Engineers Comments Regarding Surface Water Drainage

Application Reference:	A/20/26/DOC	Reviewer Reference:	ADC/EXT5/AF
Planning Officer:	Jessica Riches	Date of Review:	26/02/2026
Site Name:	Land North of Water Lane Angmering BN16 4EJ		
Application Description:	Approval of details reserved by condition under A/248/21/PL relating to condition 29 -As Built Drainage.		
Assessment Number:	1

Response	Condition 29: Further information required
-----------------	---

GENERAL NOTES

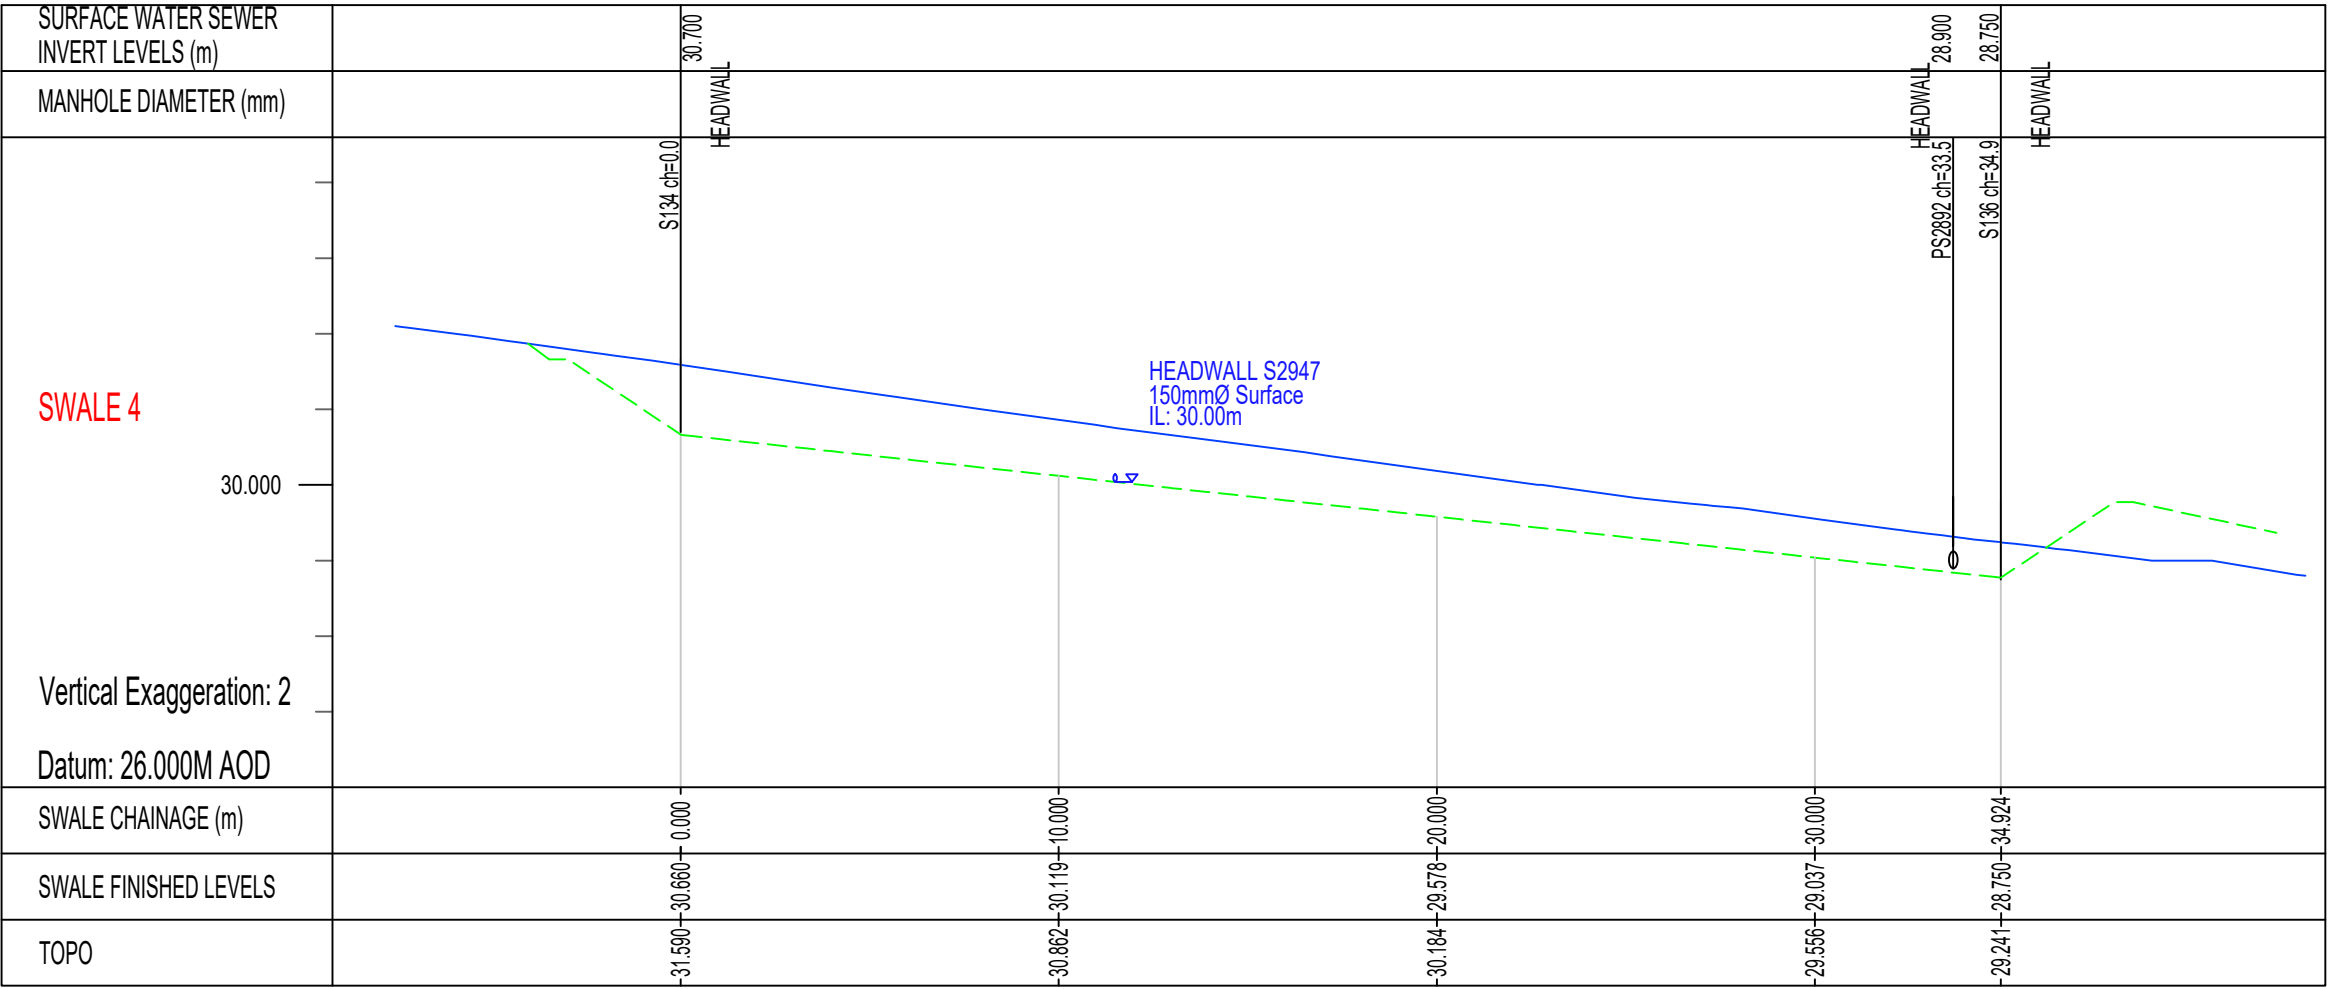
5.	The swales include storage provision and/or design storm flows as part of the sustainable drainage system. An as built measured survey should be provided and confirmation through volumetric comparison with the approved technical design that the as built capacity is fit for purpose.
